App: AL/87/21/PL

Proposal: Erection of a warehouse (Use Class B8) with ancillary office, associated vehicle parking, van storage, plant, ancillary structures, lighting landscaping and infrastructure works including earthworks to facilitate flood compensation area. This site may affect listed buildings, may affect the character & appearance of the Shripney Conservation Area, is a Departure from the Development Plan, affects a Right of way & is in CIL Zone SP3 (Zero Rated) as other development.

Address: Oldlands Farm Newlands Road Bognor Regis PO22 9FJ

client	
project	scale 1:500 @ A0
Oldlands Farm, Newlands Road, Bognor Regis PO22 9FJ	date 1st June 2021
title	drawn CJO
Landscape Strategy Plan	checked RH
drawing number	revision
05-991-300	A

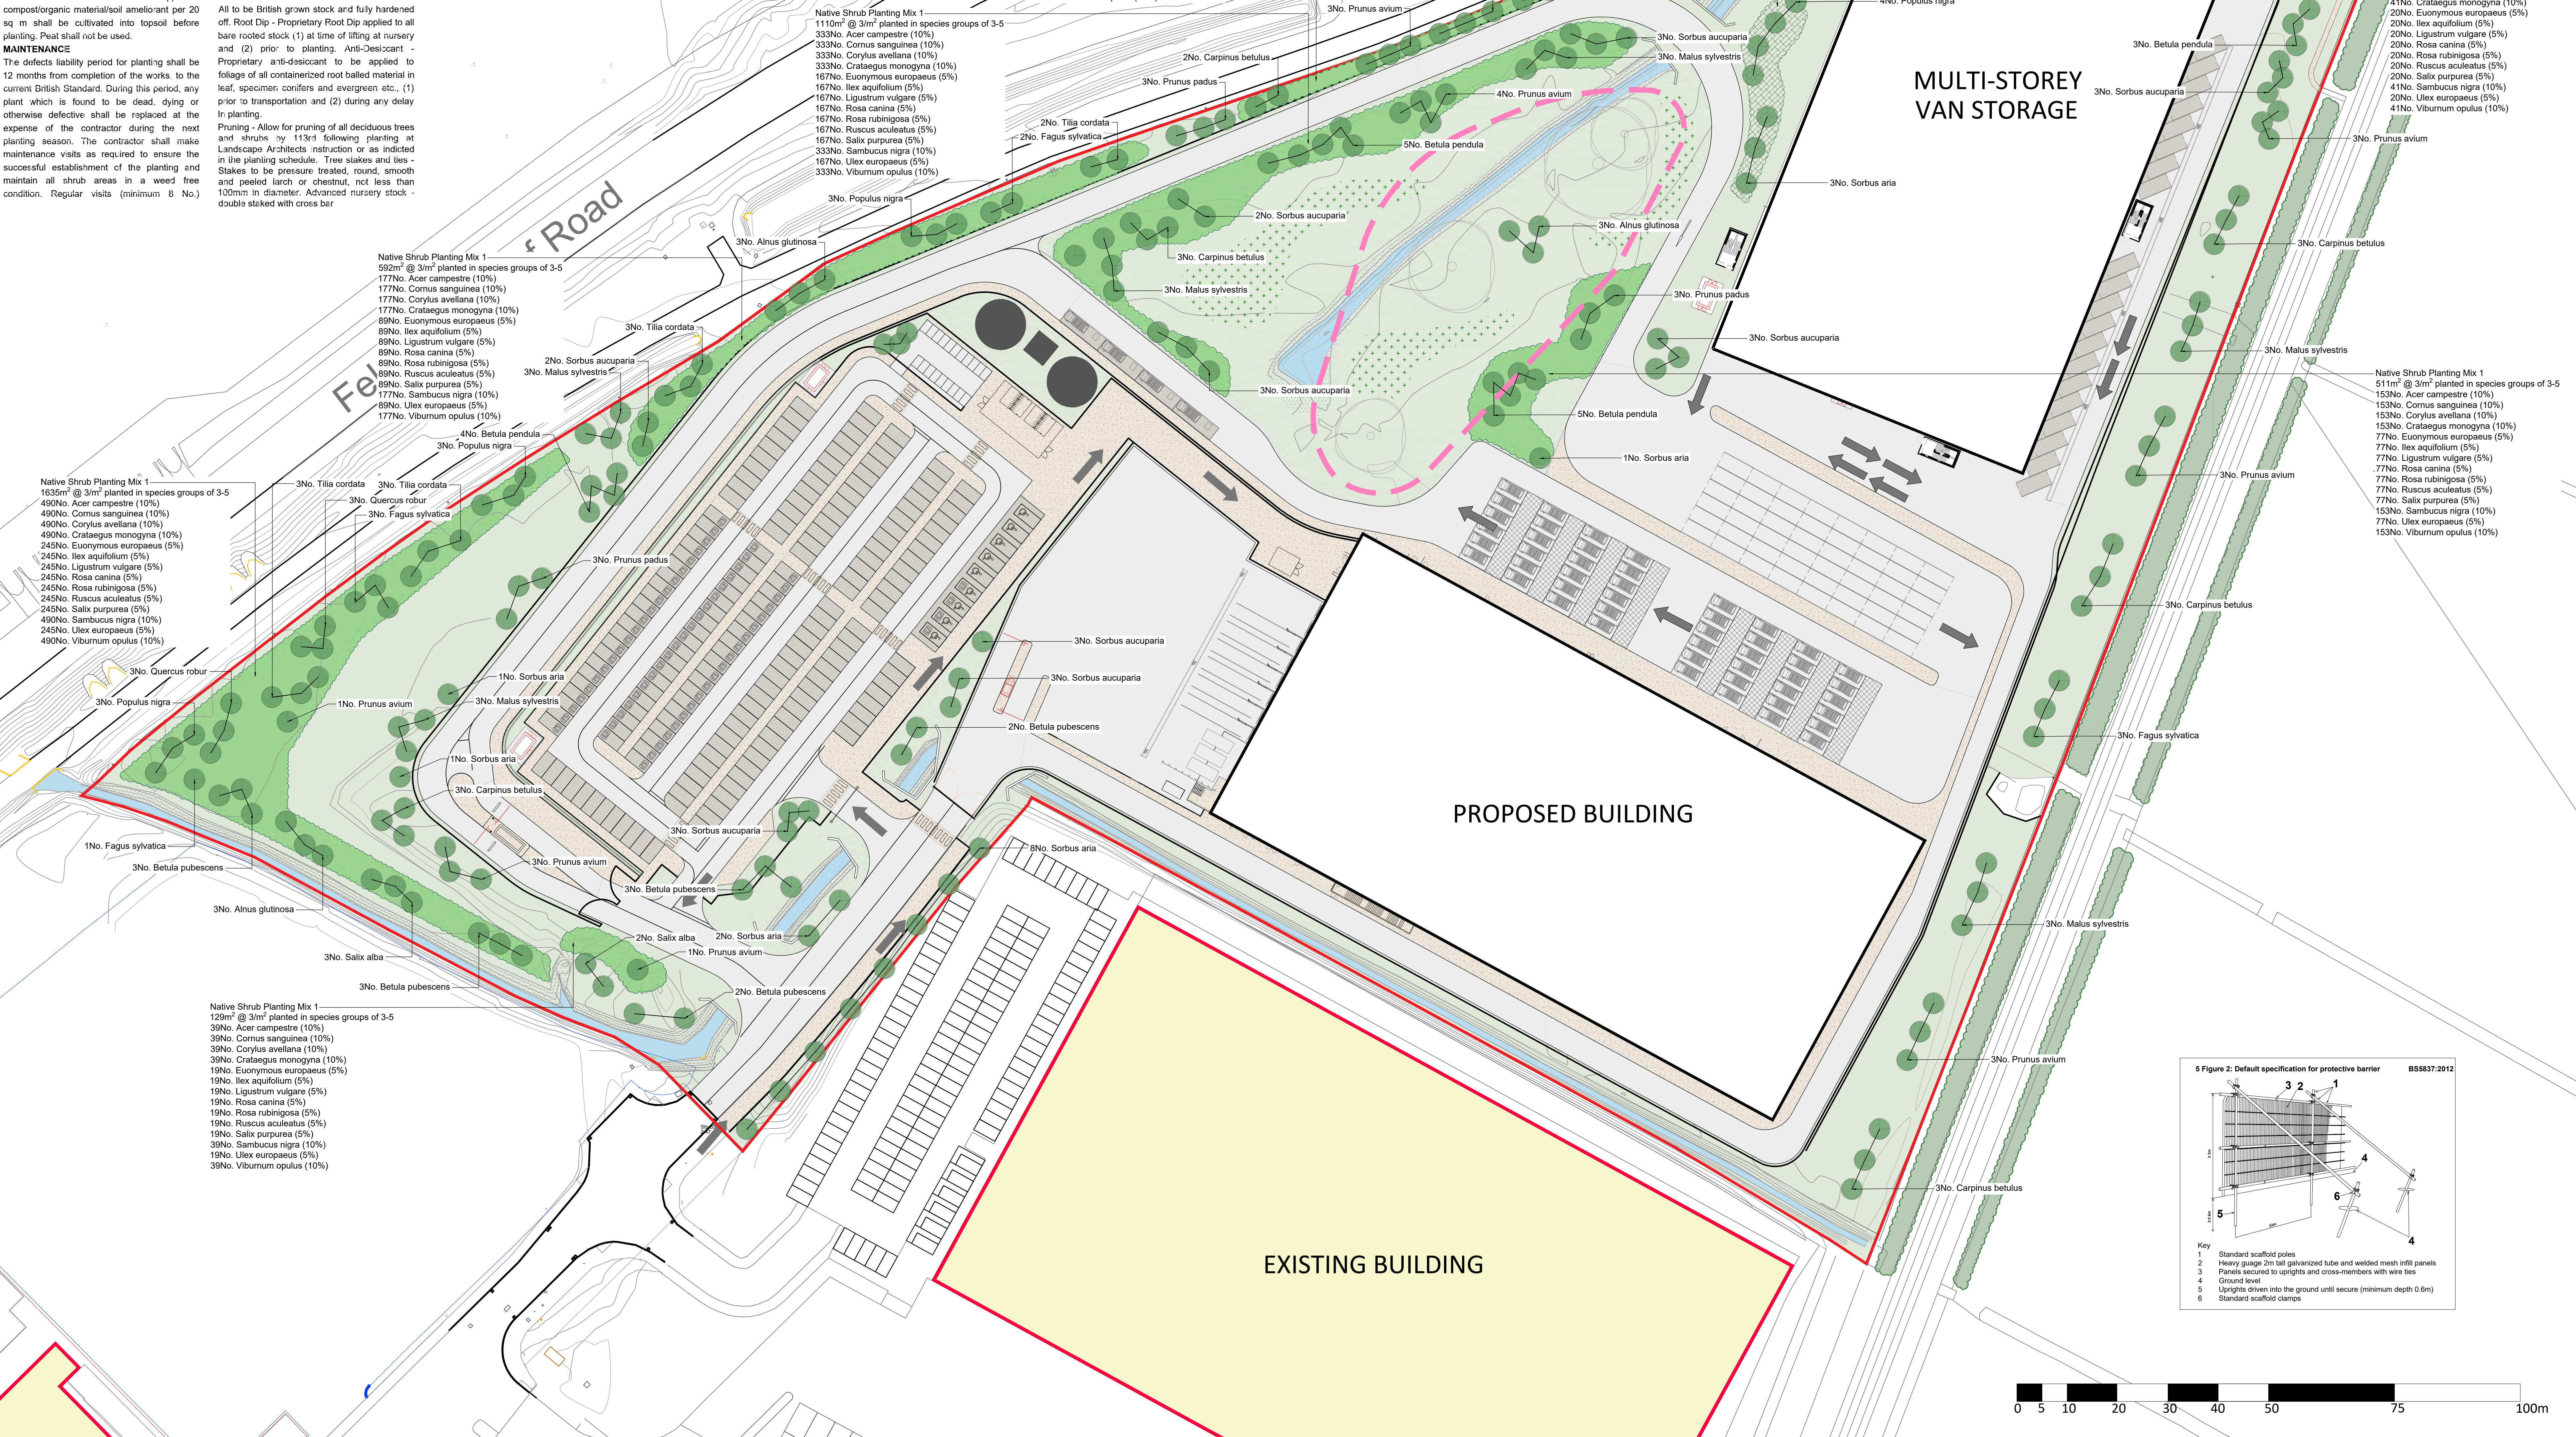
Ecological enhancements proposed in section 6.3.3 are suitable for this development and a condition used to ensure this. However, we would like to see further enhancements to be incorporated within the scheme and shown within the landscaping strategy. Such as:

- Log piles onsite
- Gaps included at the bottom of the fences to allow movement of small mammals across the site
- One hedgehog box should be installed on site
